Item No. **Report of the Head of Planning, Transportation and Regeneration**

Address 14 TRUESDALES ICKENHAM

Development: Removal of soft landscaping in front of house, replaced with brindle block paving and a planting bed for 1 additional car park space within original boundaries (Restrospective)

LBH Ref Nos: **73684/APP/2019/41**

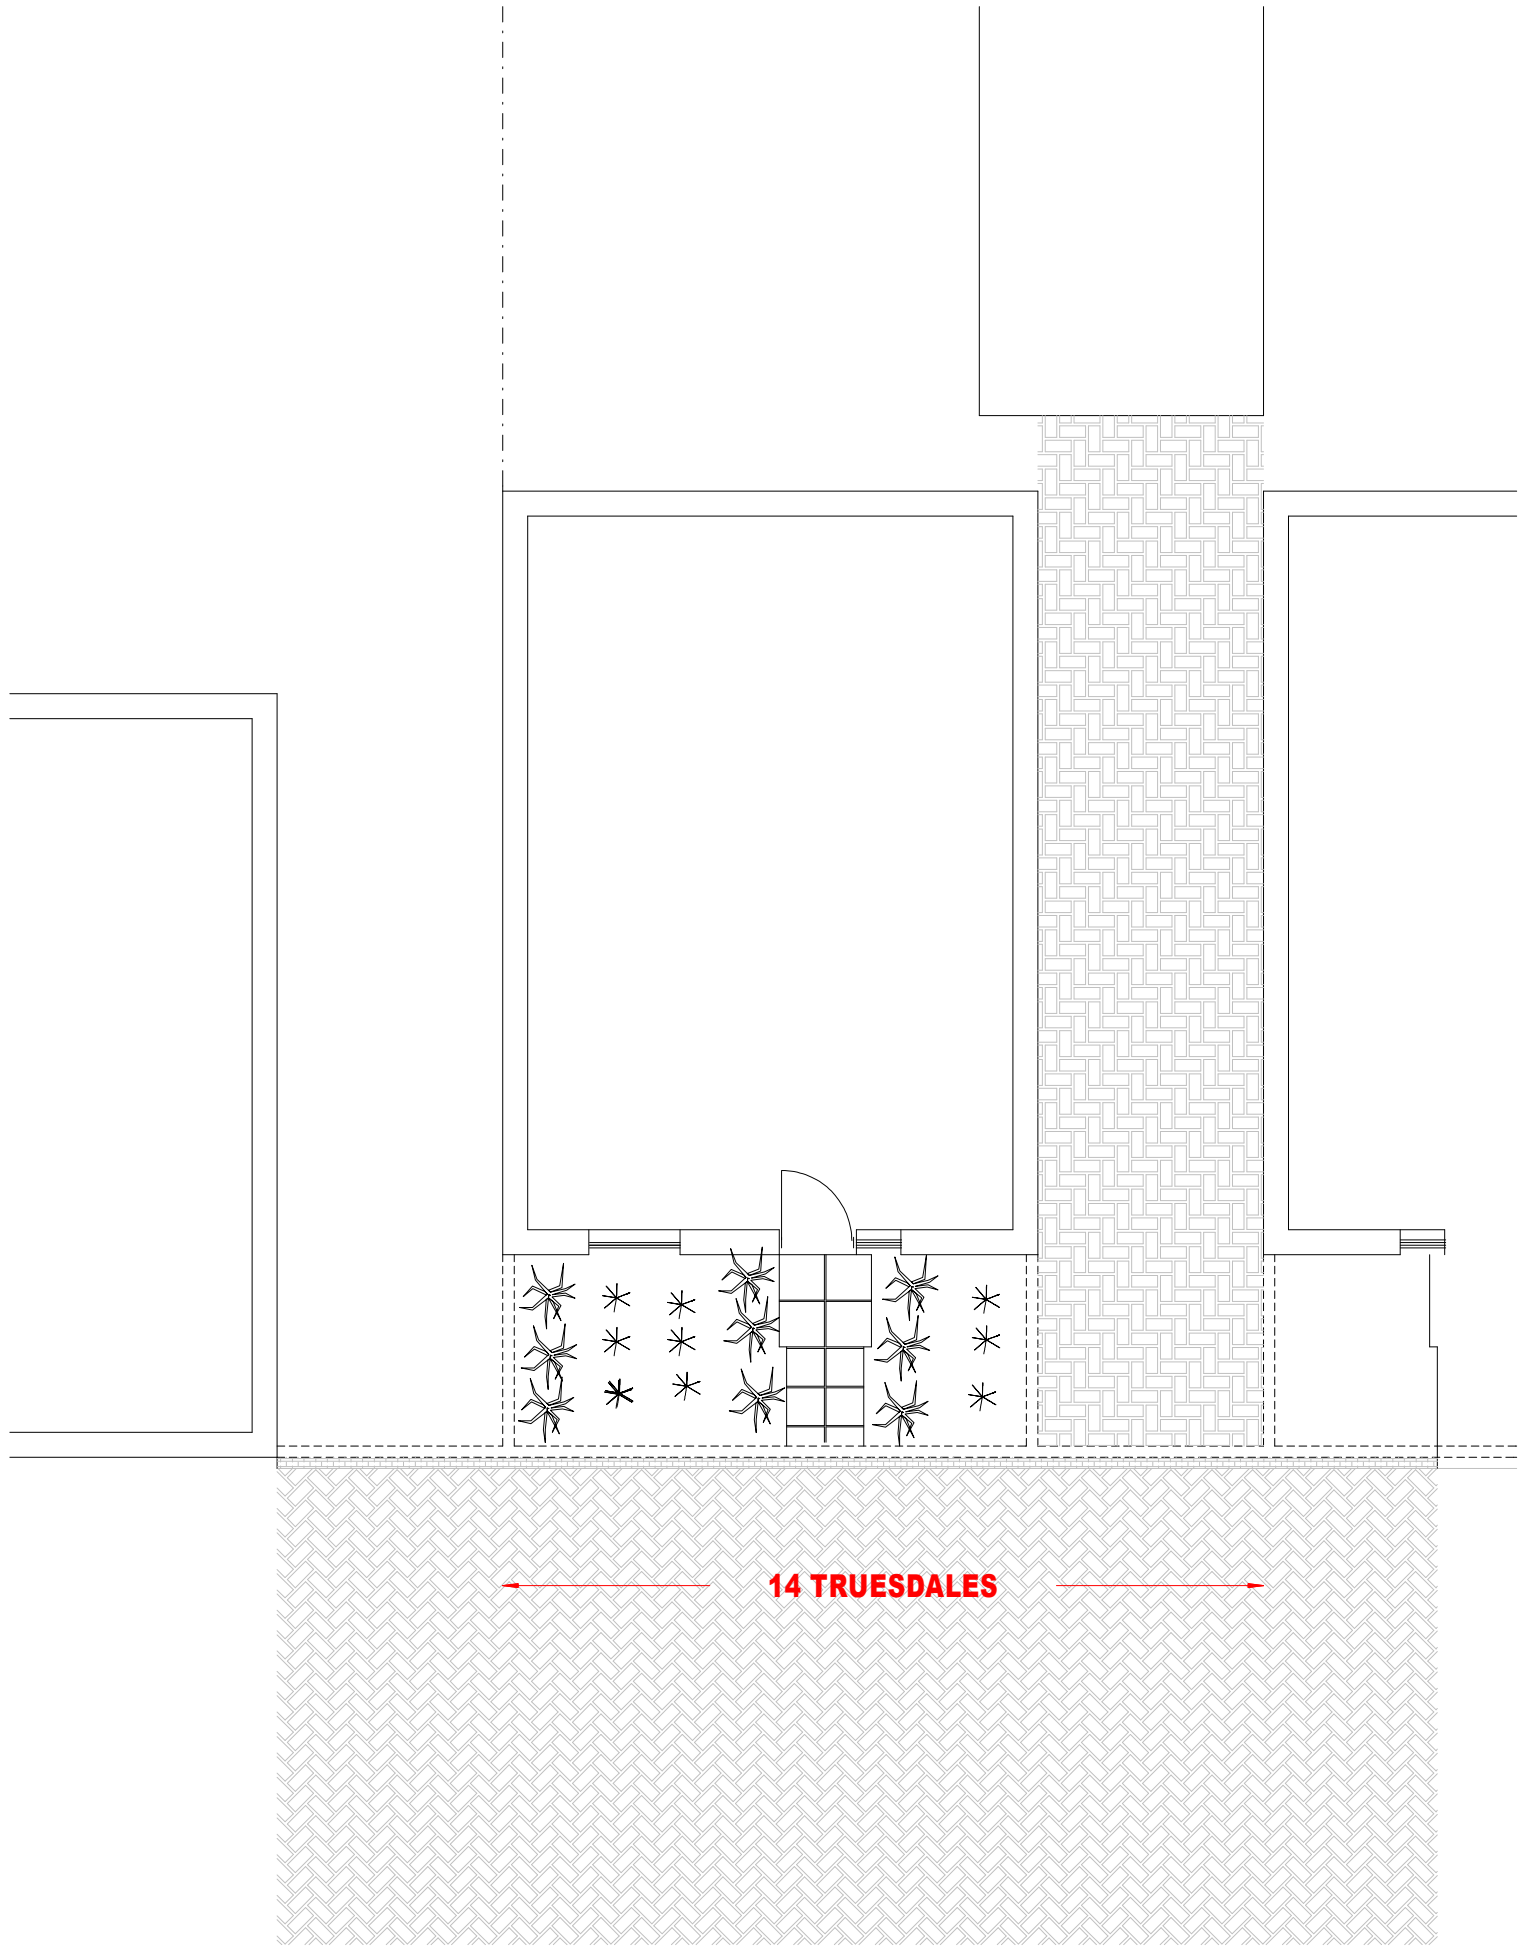
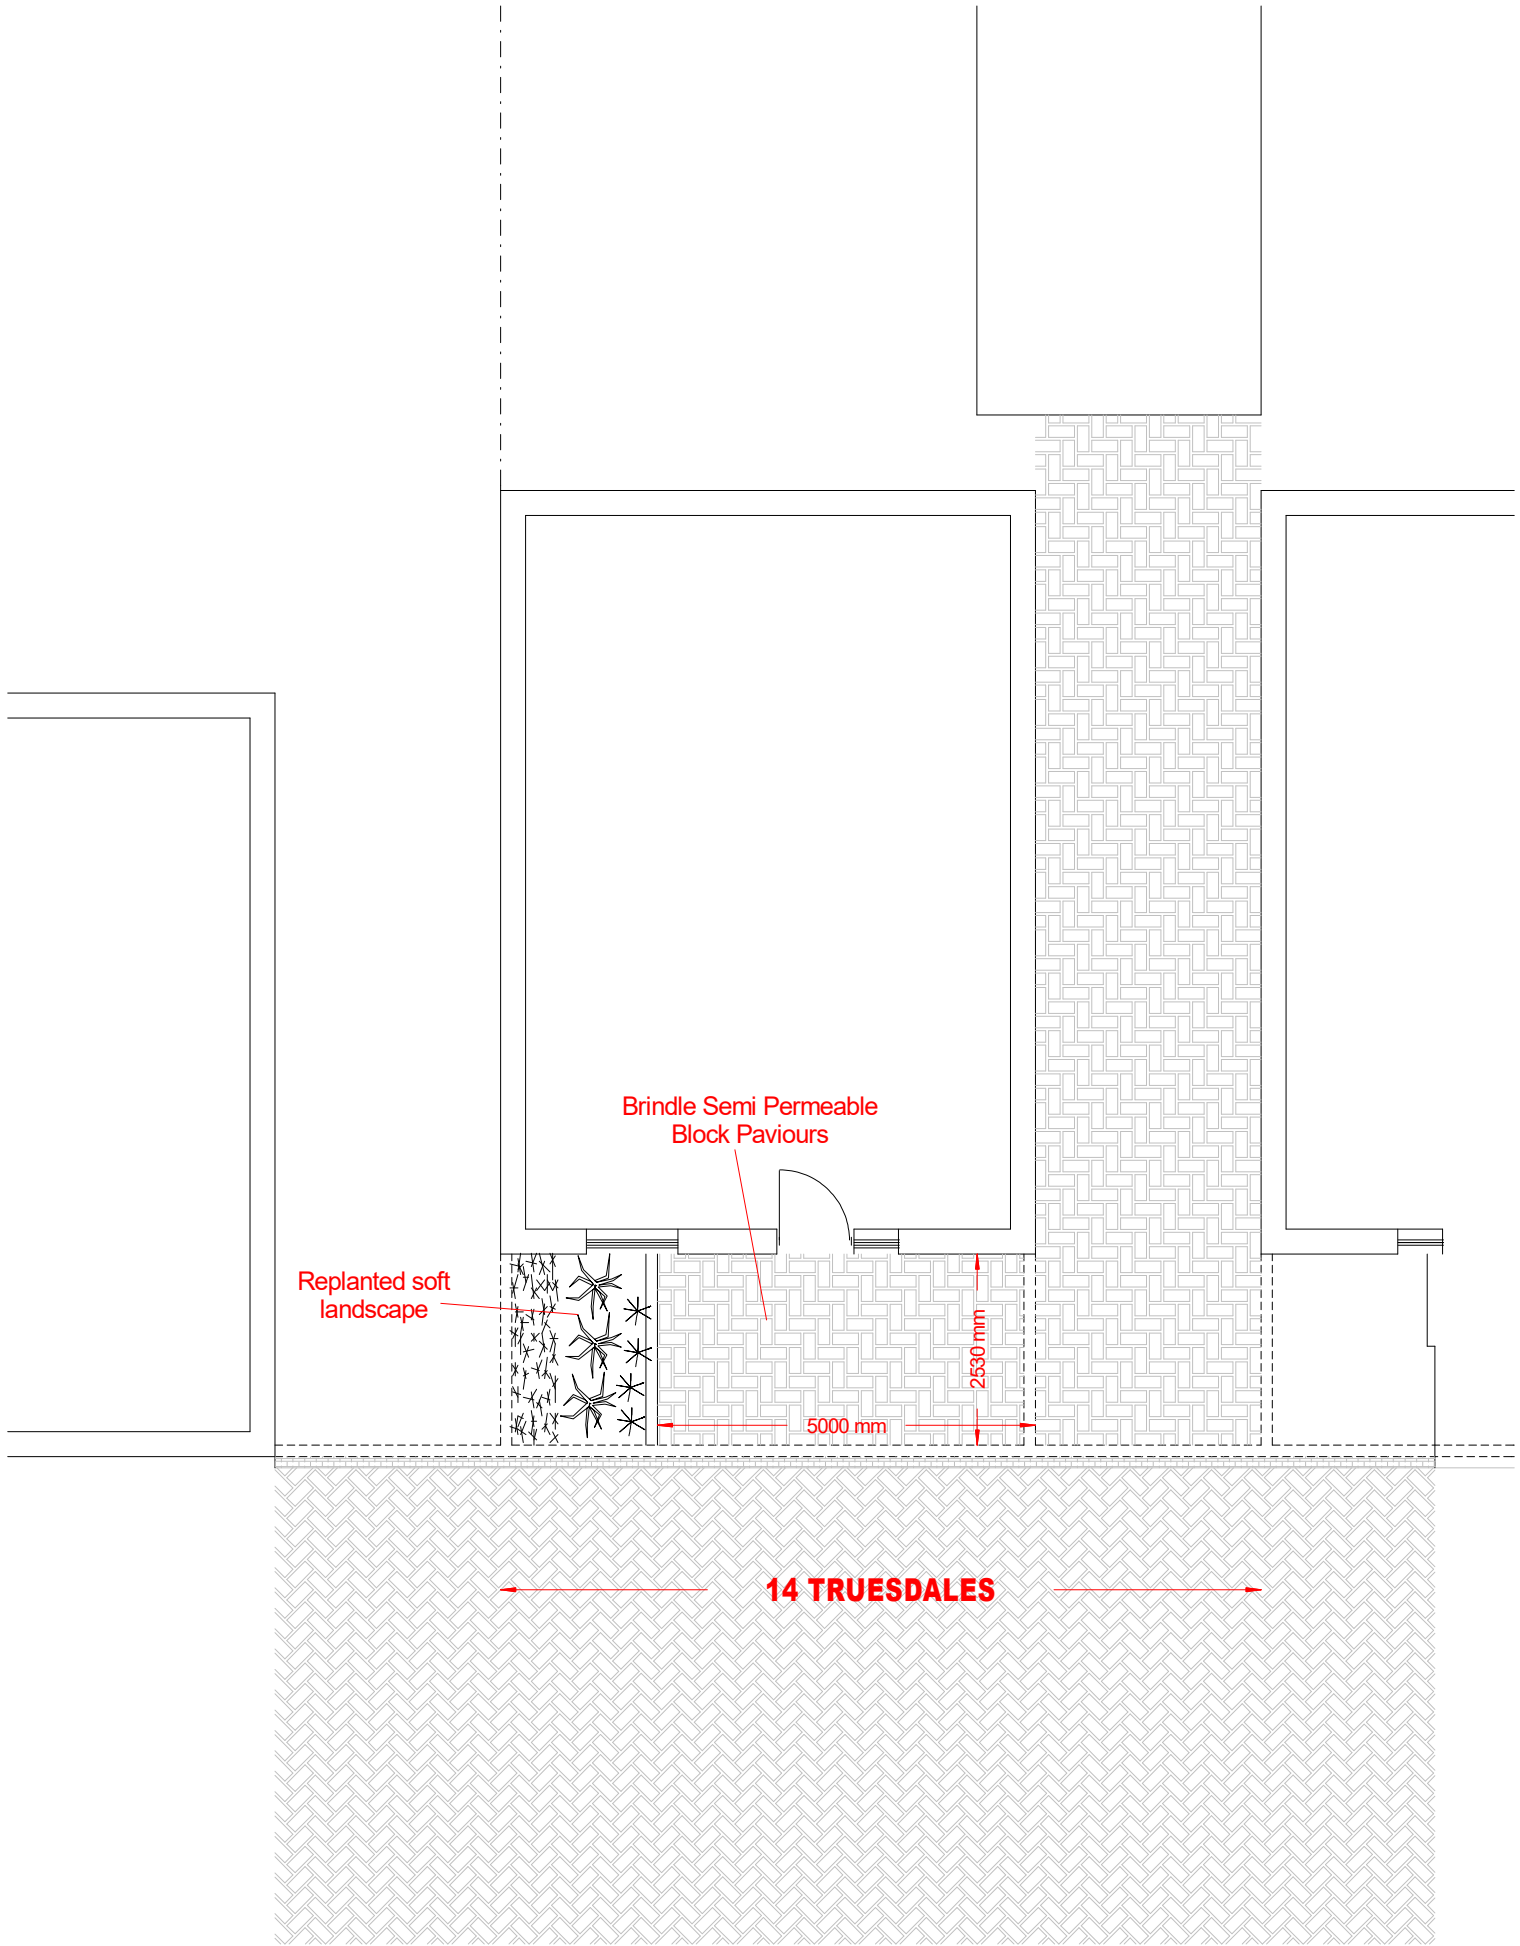
COMMENT: The current application is little better than the previous with a small area of additional planting artlessly added to the existing plants at one end of the front 'garden'. This recently completed development provides a single garage to the side / rear of this property with a driveway which can accommodate a further two parked cars. One of the design principles for this compact development was to avoid cluttering up the house frontages and shared car/pedestrian thoroughfares with parked cars. The approved site layout included front gardens which are intended to soften the appearance of the built environment and provide an attractive setting for this residential area. Furthermore the planting is intended to provide wider environmental benefits to address issues such as

RECOMMENDATION: The provision of an additional car park space at the expense of the approved landscape layout is unacceptable and contrary to saved policies BE23 and BE38. The previous reason for refusal remains valid. The soft landscaping should either be reinstated in accordance with the approved plans or re-designed to provide an attractive frontage to this property which prevents car parking in front of the house.

The 'as built' scheme does not conform to the approved plans under ref: 38402/APP/2007/1072 (09-07-07) and has resulted in the loss of soft landscaping to the detriment of the character and appearance of the site and the local setting.

This residential estate is a compact development featuring shared surfacing for pedestrian and vehicle movement. The amount of green infrastructure is limited to very small front gardens which make an important contribution to the character and appearance of the area. The provision of an additional car park space at the expense of the approved landscape layout is unacceptable and contrary to saved policies BE23 and BE38 of the

The proposal involves the loss of existing landscaping which make an important contribution to the character and appearance of the area. The loss of the landscaping is considered to be detrimental to the visual amenity of the street scene and the wider area contrary to Policies BE19 and BE38 of the Hillingdon Local Plan: Part Two - Saved UDP Policies (November 2012) and the adopted Supplementary Planning Document HDAS: Residential Extensions.
